DECISION DELEGATED TO HEAD OF PLANNING

Application No: H05-1098-24 **Applicant:** G Geerlings & Son
Proposal: Conversion of agricultural building into dwelling including extension
Location: The Gables Nursery New Fen Drove Gedney Hill
Terminal Date: 27th February 2025

CASE OFFICER ASSESSMENT

Proposed Layouts and Elevations

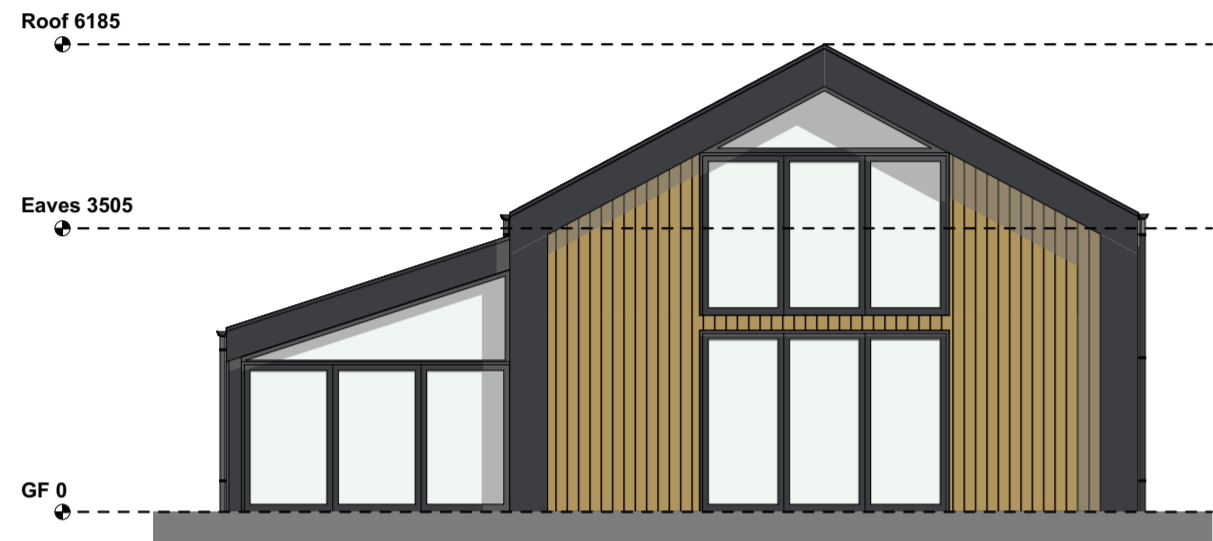
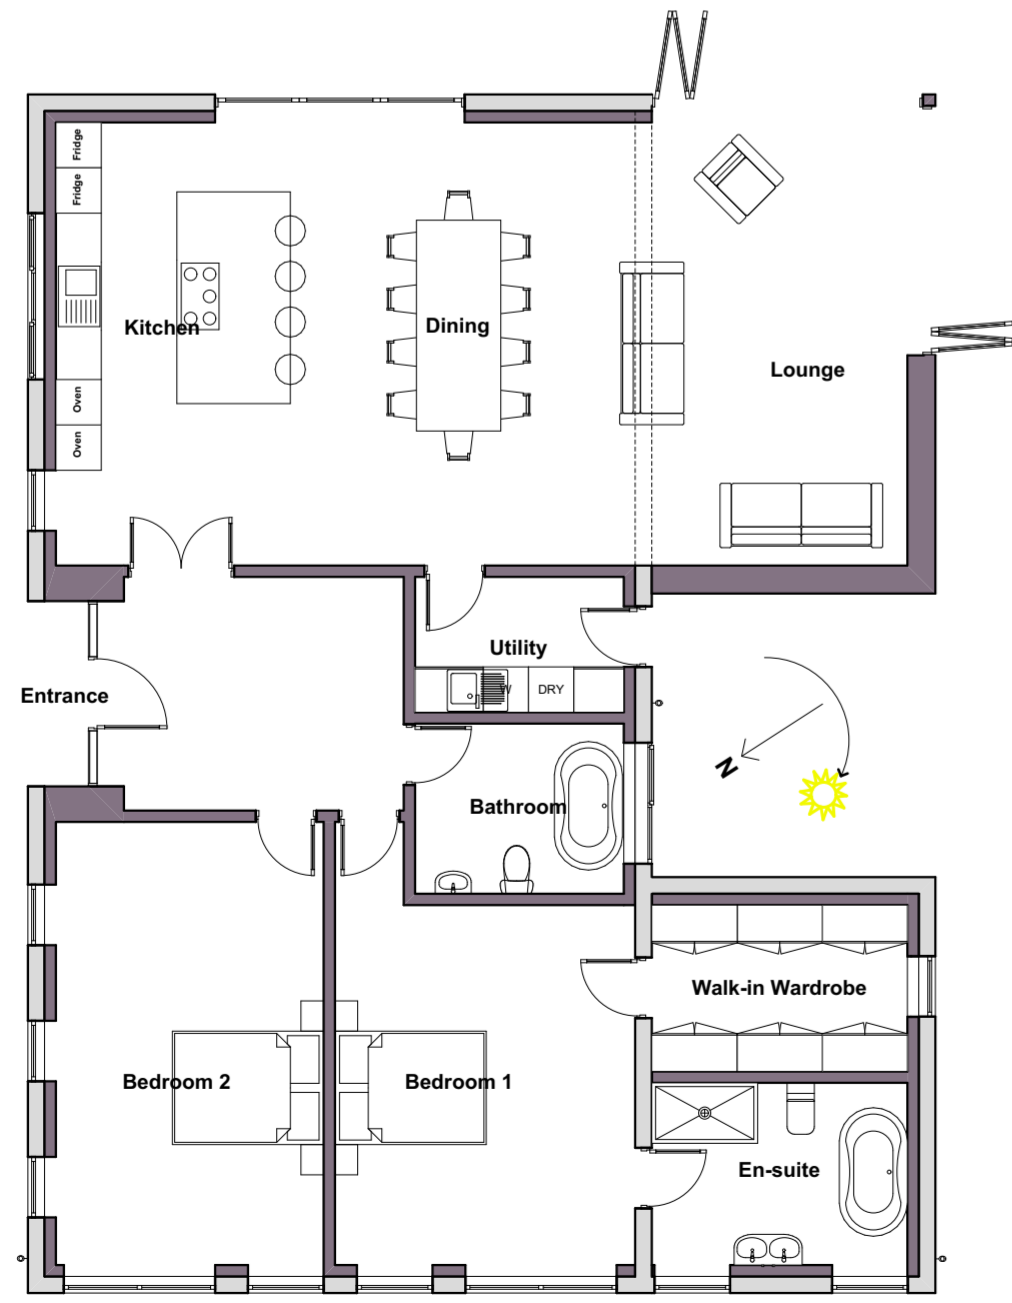
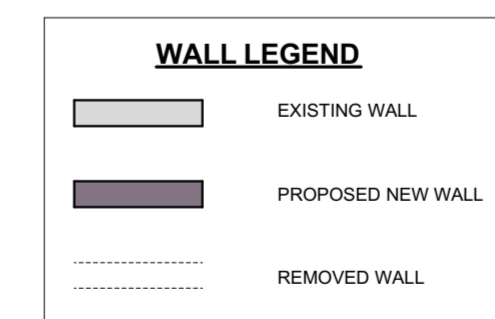
The information provided by the applicant appears to satisfactorily demonstrate that the provisions of criteria (a) - (h) and (k) to (p) have been met. The proposal seeks to extend the built form on the western elevation projecting from the existing building by 3.75m. The extension is also to be single storey in height and therefore, the proposal would not be at conflict with criteria (i).

(f) Design/external appearance - No material schedule was submitted with the application; the Local Planning authority are therefore unsure on the finished materials. The proposed elevation drawings indicate a cladded finished with heavy glazing to the west (side) elevation. The building is currently brick. The windows and door to the northern elevation (front) are to be significantly altered, all new window designs are proposed on the southern (rear) and eastern (side) elevation. The Local Planning Authority are unsure on the roof materials and the elevation finishes.
